Response to Submissions Reports

MP10_0204 MOD 6

Property:
Catherine Hill Bay

Applicant:
Coastal Hamlets Pty Limited

Figure 7: Proposed Stage 7 subdivision layout with the internal road removed.

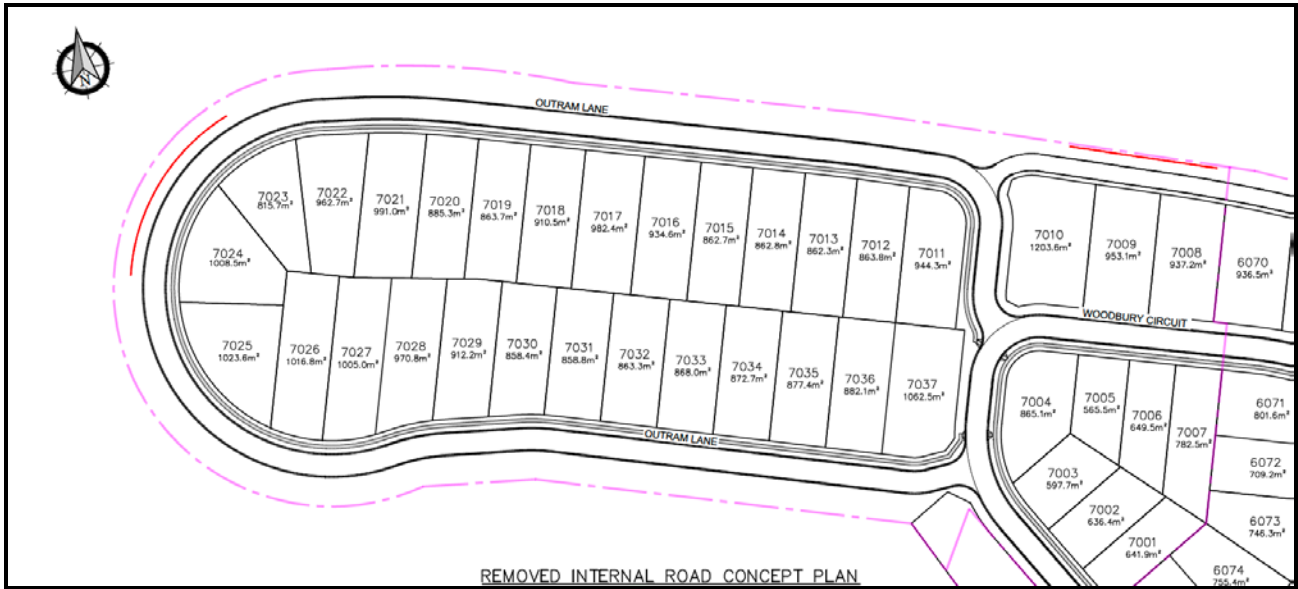
1. Details demonstrating that the modified perimeter road is linked to the internal road system at intervals not exceeding 500 metres, as required as an acceptable solution under Section 4.1.3 (1) of 'Planning for bush Fire Protection 2006';
2. Advice detailing the front building alignment for the proposed residential lots, and the expected bushfire attack level (BAL) ratings, as determined under the Australian Standard AS3959-2009, for future dwellings on those lots.

1. Details demonstrating that the modified perimeter road is linked to the internal road system at intervals not exceeding 500 metres, as required as an acceptable solution under section 4.1.3 (1) of 'Planning for Bush Fire Protection 2006'.
2. Advice detailing the front building alignment for the proposed residential Lots, and the expected bushfire attack level (BAL) ratings, as determined under the Australian Standard AS3959-2009, for future dwellings on those Lots.

To address Item 1, a revised lot layout and road network was prepared and provided to RFS, refer to Figure 2. This subdivision layout ensures that the perimeter road is linked to the internal road system at intervals less than 500m as required.

Figure 8: Location of approved road sections requiring 6.5 metre high retaining walls.

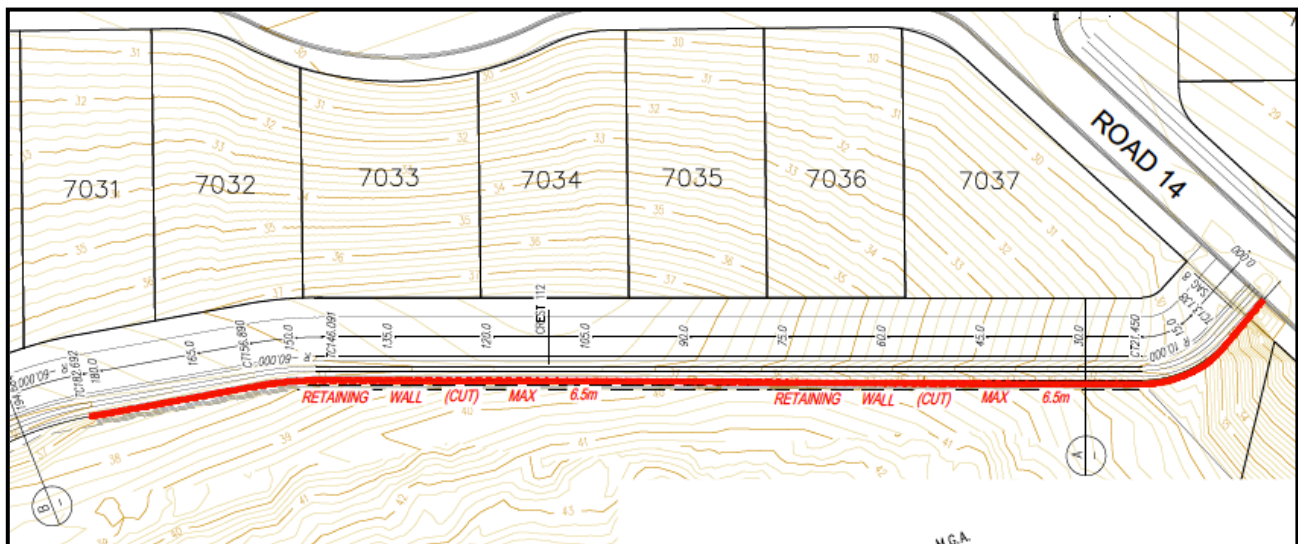
1. All retaining walls required within the subdivision should be made from decorative masonry and should be located outside of the public road reserve;
2. There does not appear to be any provision for the treatment of stormwater in Stage 7. Council's normal requirements are that stormwater detention and stormwater quality controls are provided for stormwater prior to the stormwater being discharged offsite.
3. The stormwater from Stage 7 is proposed to be discharged directly to the adjoining National Park without stormwater treatment (as identified in point 2 above) and without the provision of easements on the National Park lands.

1. All retaining walls required within the subdivision should be made from decorative masonry and should be located outside of the public road reserve.
2. There does not appear to be any provision for the treatment of stormwater in Stage 7. Council's normal requirements are that stormwater detention and stormwater quality controls are provided for stormwater prior to the stormwater being discharged off site.
3. The stormwater from Stage 7 is proposed to be discharged directly to the adjoining National Park without stormwater treatment (as identified in Point 2 above) and without the provision of stormwater easements on the National Park lands.

As there are excessive slopes along the subdivision boundary, and works are not permitted within the National Park lands, retaining walls are required. This is to allow the vertical alignment of perimeter roads to be designed in accordance with LMCC requirements. This approach is consistent with the methodology used in Stages 1, 2, 4 and 5 which all provide retaining walls adjoining National Park lands and are constructed within the road reserve.

It is also worth noting that the current approved Stage 7 subdivision layout would require retaining walls to be constructed along approximately 75% of the Stage 7 perimeter road and with heights up to 7m in height. The proposed MOD 6 modification reduces the extents to less than 20% of the perimeter road with maximum heights of less than 3m.
